Engineers Comments Regarding Surface Water Drainage

Application Reference:	CM/16/26/HH	Reviewer Reference:	ADC/KW/PC
Planning Officer:	Rhiannon Lloyd	Date of Review:	22/07/2026
Site Name:	3 New Thatched Cottages, Climping Street		
Application Description:	Construction of detached garage/workshop with studio over.		
Assessment Number:	1 of 1

Drawing Title
SW Drainage Layout

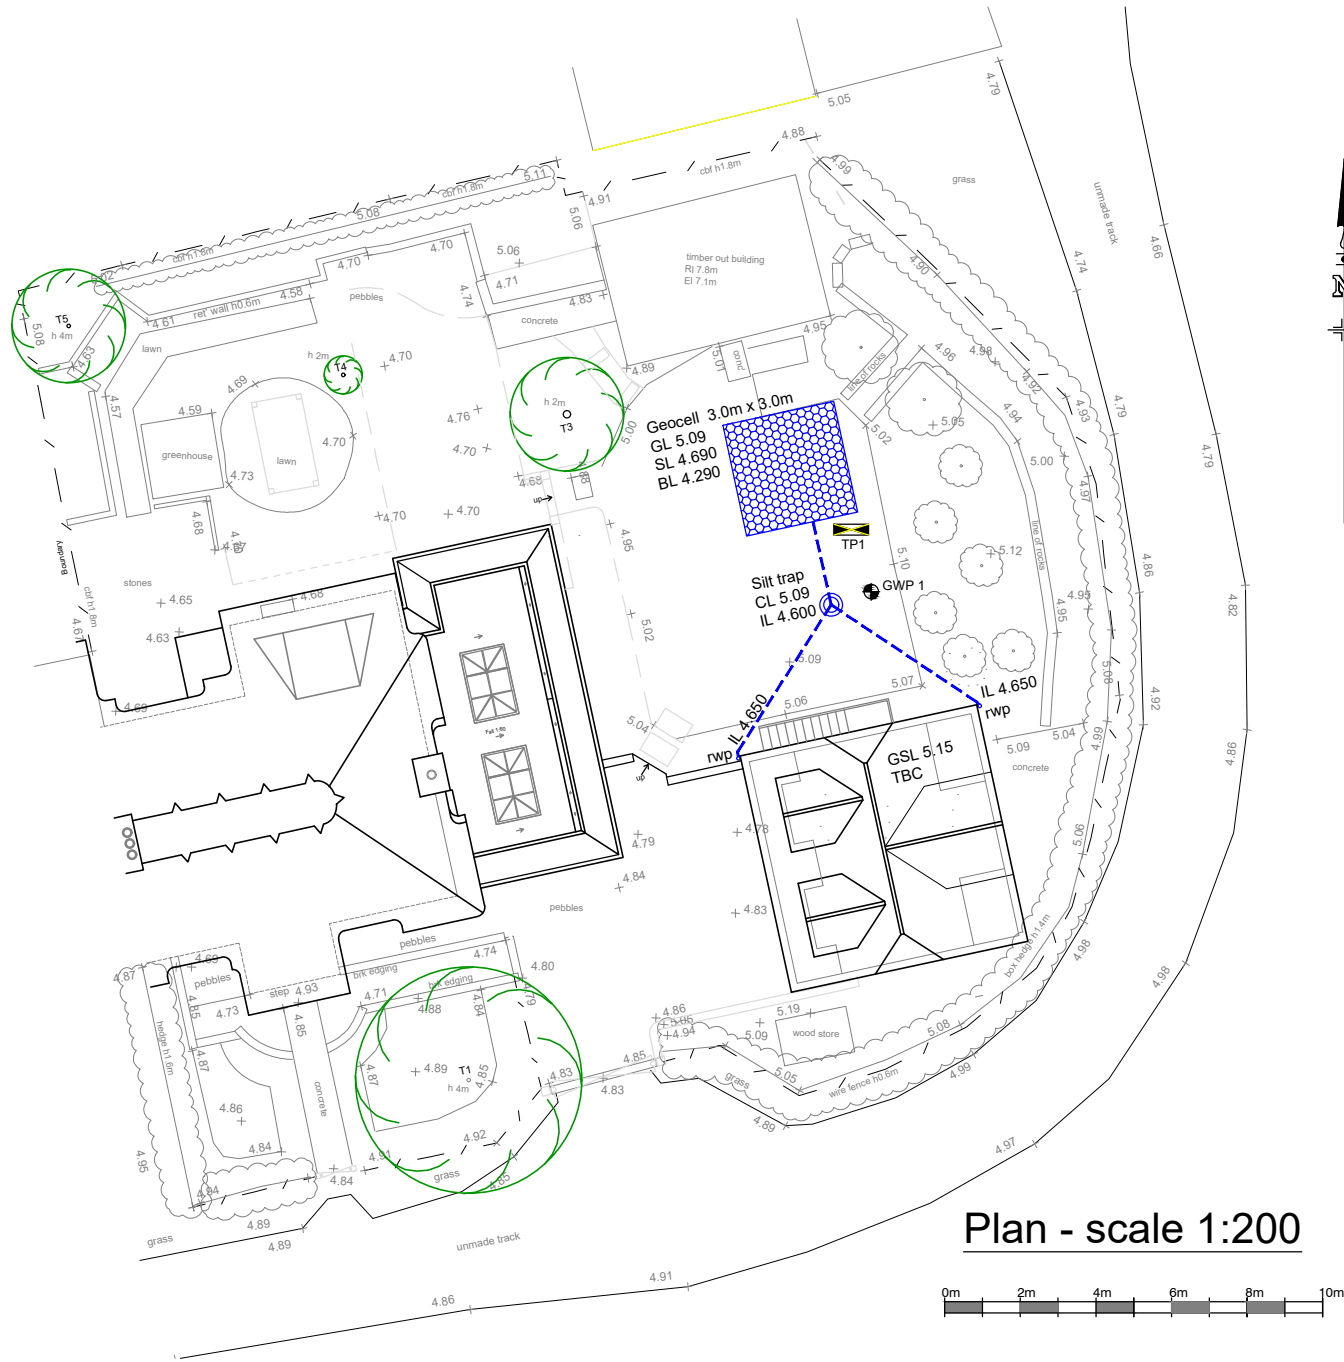
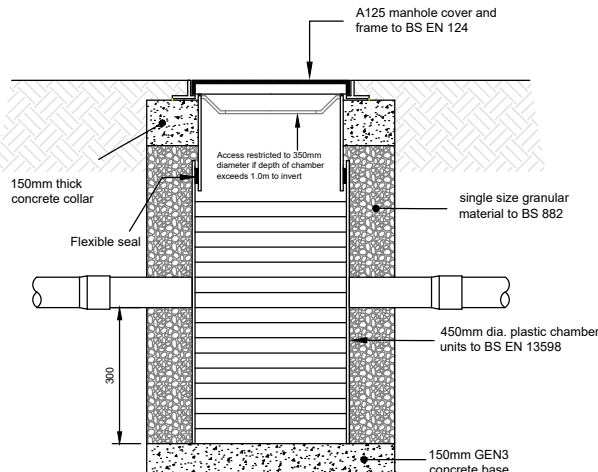
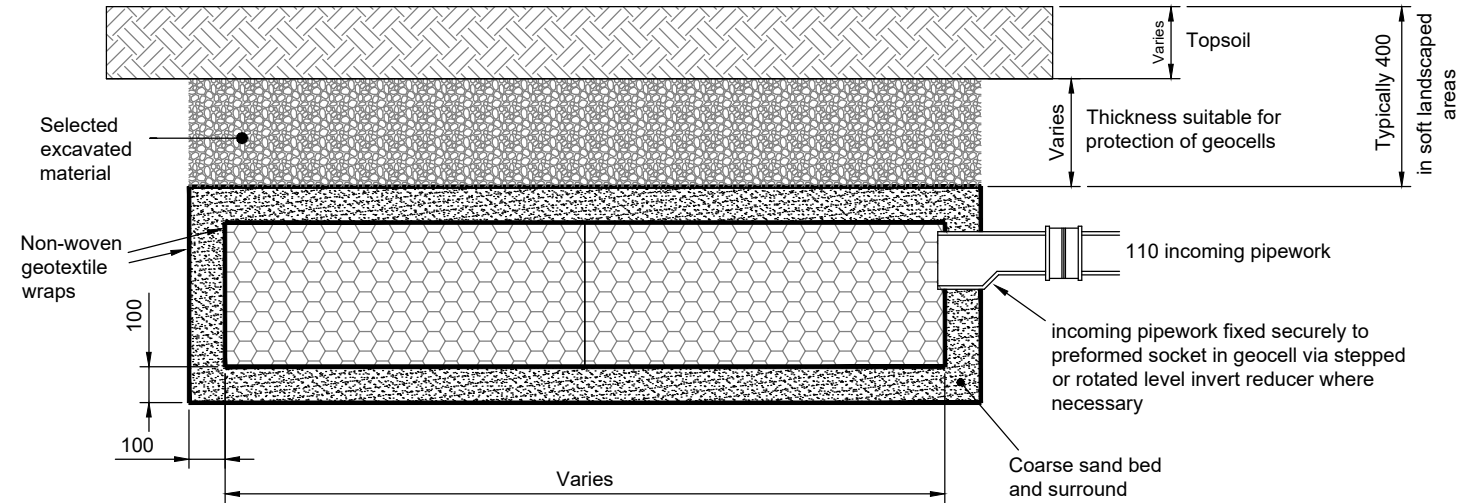
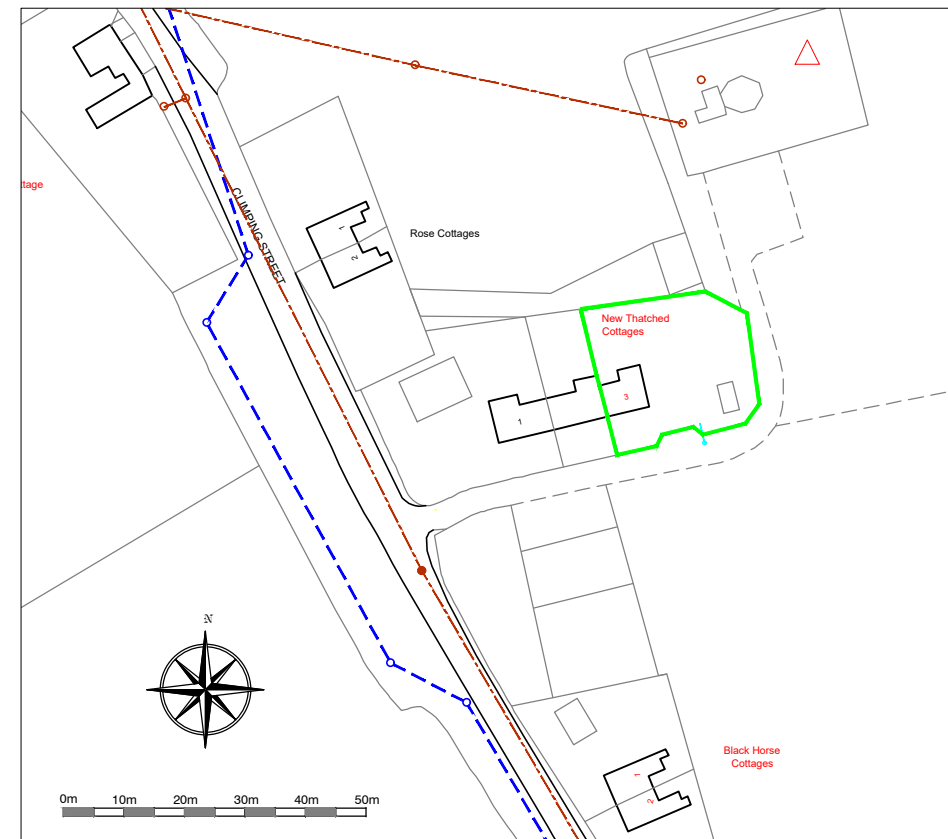
It is proposed to manage surface water on site via a new soakaway. We support this approach in principle, as infiltration is the highest priority discharge location (after water re-use) in the drainage hierarchy and aligns with Standard 1 of the Non-Statutory Technical Standards for SuDS (NSfS). However, insufficient evidence has been provided to demonstrate that infiltration is a viable solution. It is the responsibility of the applicant or their drainage designer to provide this evidence. Without it, we are unable to assess whether the proposed development would increase flood risk. For this reason **we object** to the proposal.

To support an infiltration-based design, winter groundwater monitoring must be undertaken to confirm that a minimum of one metre of unsaturated ground can be maintained between the base of the soakaway or infiltration structure and the peak groundwater level. Ground conditions and infiltration potential in Climping are highly variable. While infiltration may be feasible in some areas, others experience high groundwater levels or poor infiltration rates that render it unviable. This must be robustly demonstrated by the applicant. The FRA indicates ground water monitoring has been undertaken, this should be submitted to support the design.

The results of infiltration testing have also been provided, however the details of each test have not been submitted in support of this, including test depth. We would also expect details of the soil composition for the trial pit to be evidenced.

There is a public surface water sewer located to grass verge in the opposite side of the highway. No information regarding this option has been submitted. If infiltration is not viable, the applicant would need to investigate the possibility of connecting surface water to this sewer via Southern Water.
